**November 16, 2018**

Project Name: **Conversion of Sala Thai to Taco Bell with drive-through**  
 Project ID: #2016-007  
 Address: 1363 Washington Avenue, Portland CBL: 401 A002001  
 Applicant: Guggenheim Retail Real Estate Partners, Inc.

**NOTIFICATION OF NON COMPLIANCE WITH SITE PLAN APPROVAL**

**C-2**

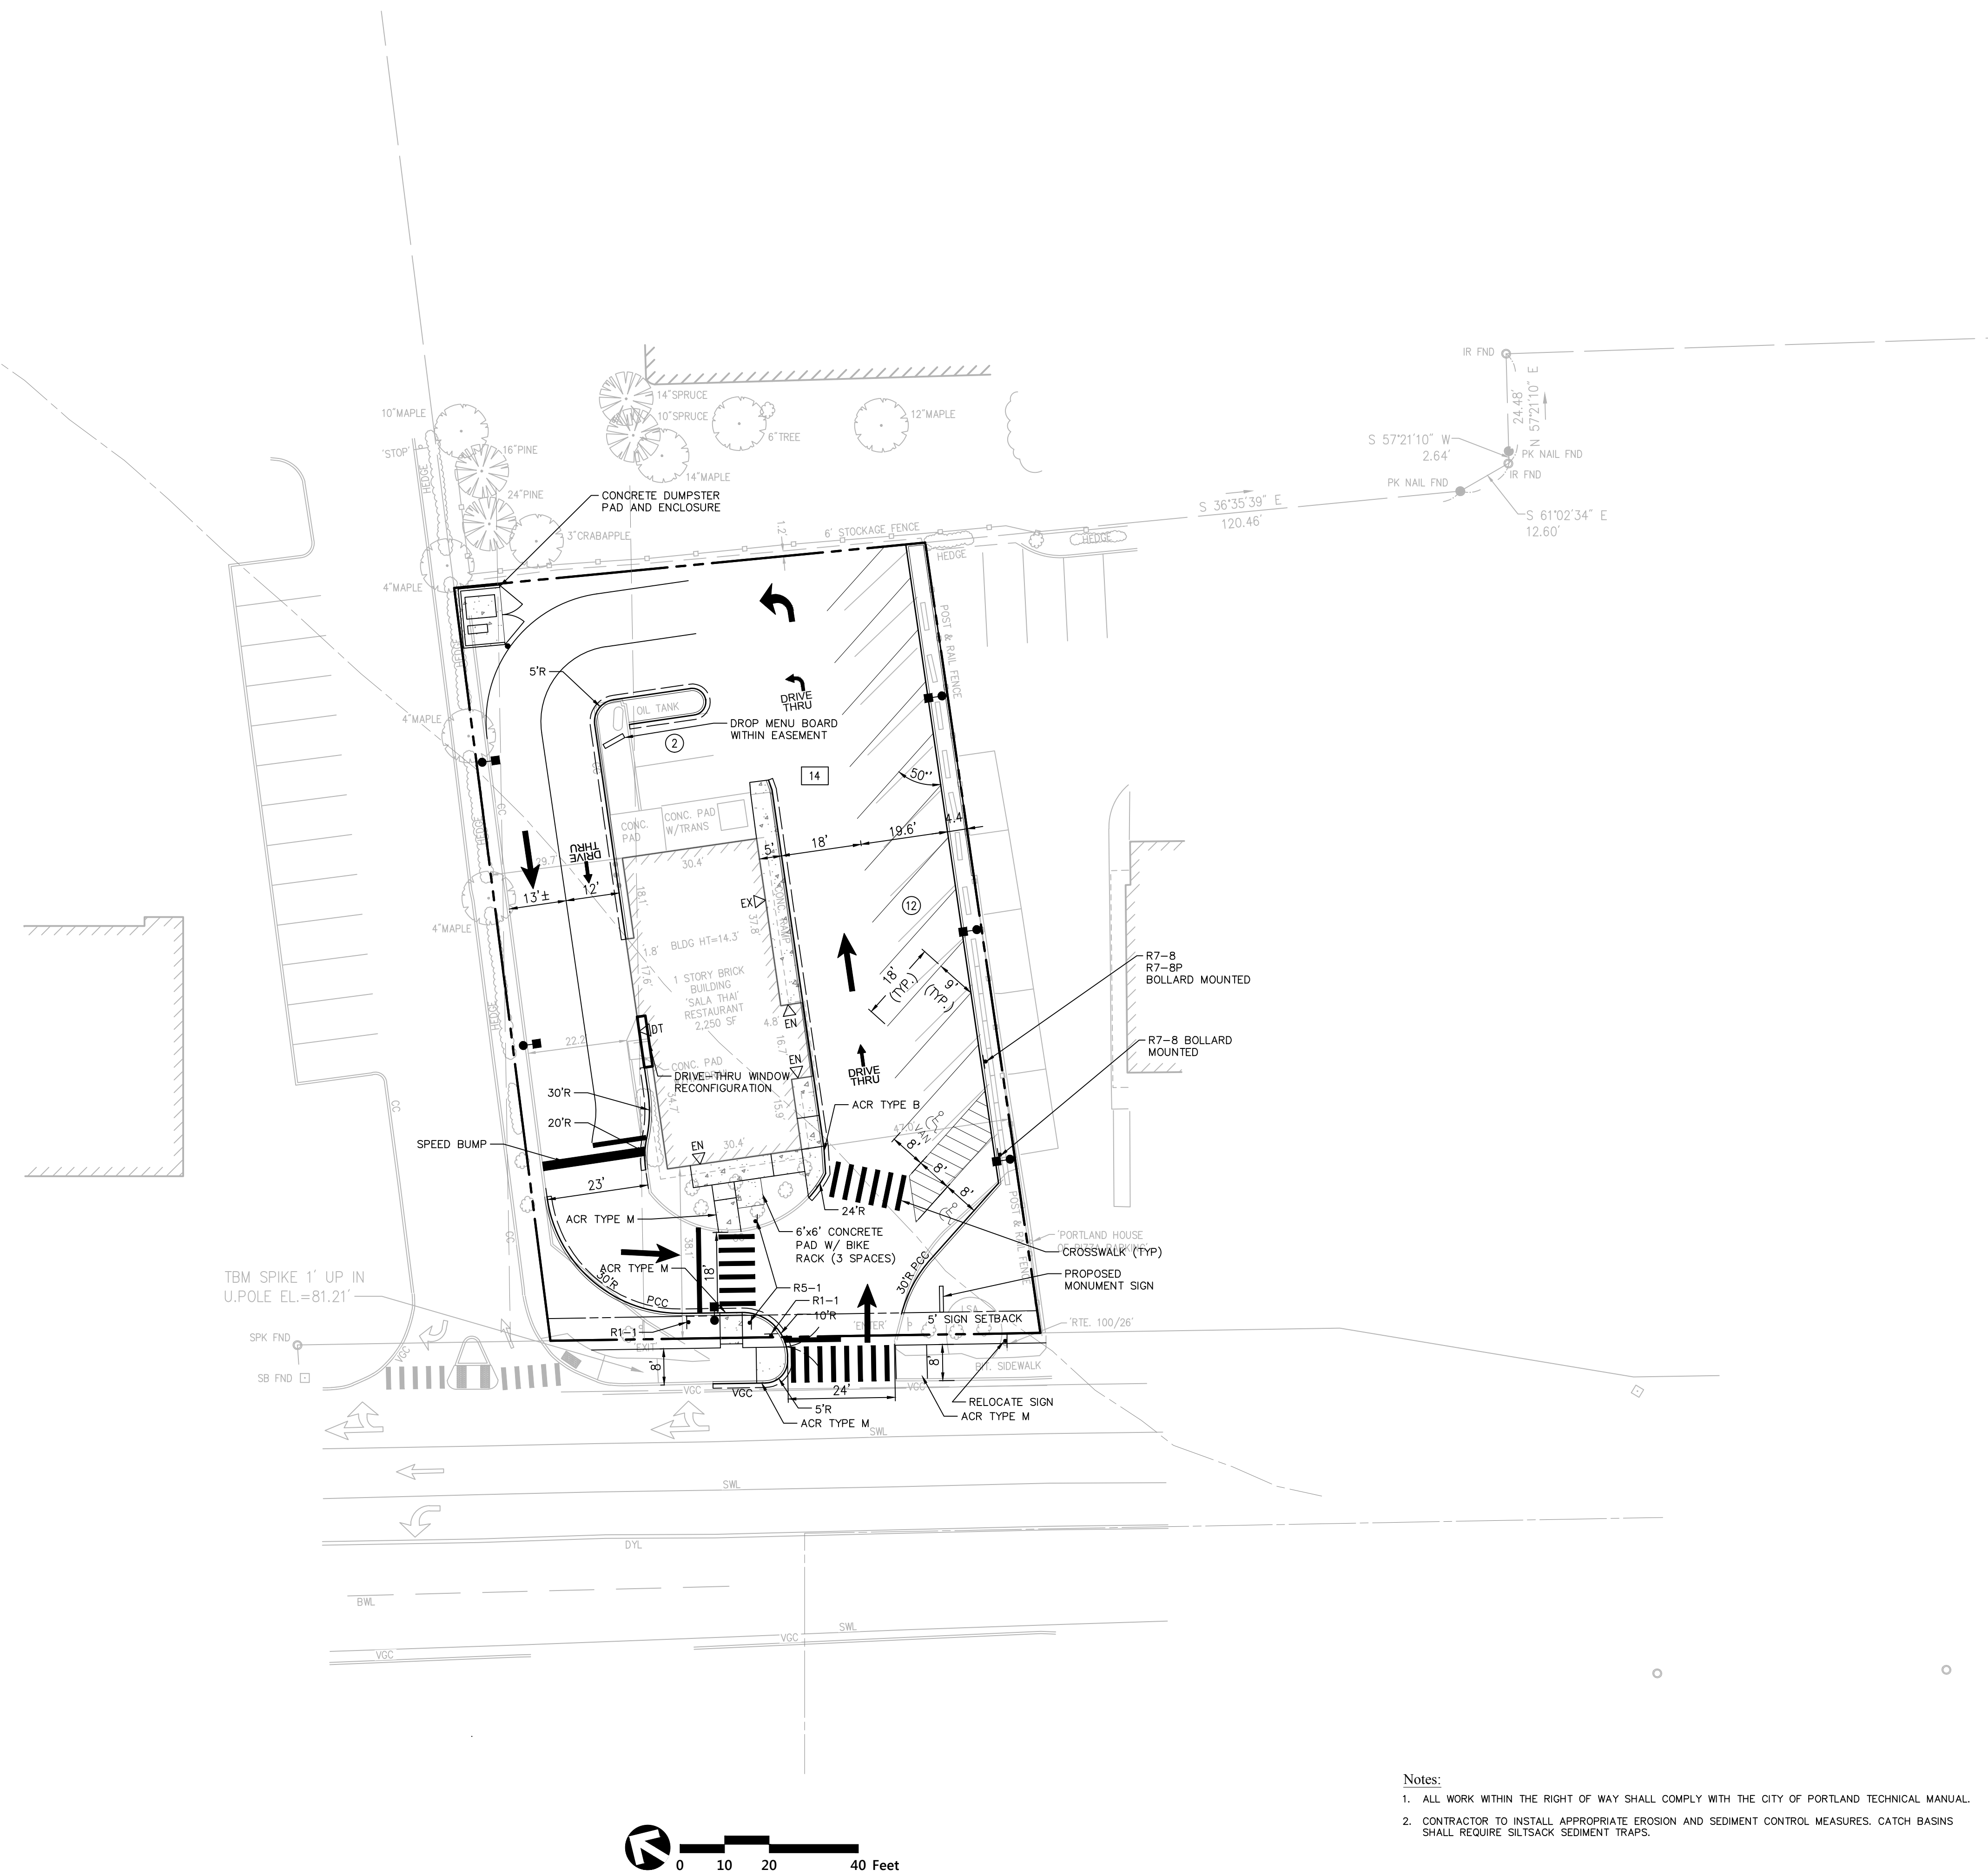
- Although the 2-way connection to the abutting Rite Aid driveway is the City's preferred solution to the access issue, the applicant/owner has declined to pursue or implement this option to meet condition ii; therefore condition i applies.
- In accordance with the condition i of the approval, the City received from the agent/applicant a *Crash Monitoring Study* that confirms that the full turn access for Taco Bell has unreasonably contributed to crashes along Washington Avenue.

Therefore, based on the *Crash Monitoring Study* and in accordance with the conditional site plan approval, the City has concluded that the full turn access must be modified to restrict the access, so it is right in and right out only, in order to mitigate the safety problem that has been created by the full turn access. The required modification comprises the construction of a 2 foot wide median in Washington Avenue, topped by flexible bollards, that would restrict the left turn vehicle movements to and from the Taco Bell site. The condition specifies that the applicant shall make such a modification.

We request that you prepare the plan for the median within one month of the date of this letter, and arrange for obtaining street opening permits and complete construction within 5 months of the date of this letter. Please note that in the short term the City will be erecting sign(s) in the right-of-way indicating that the left turn out of Taco Bell is prohibited.
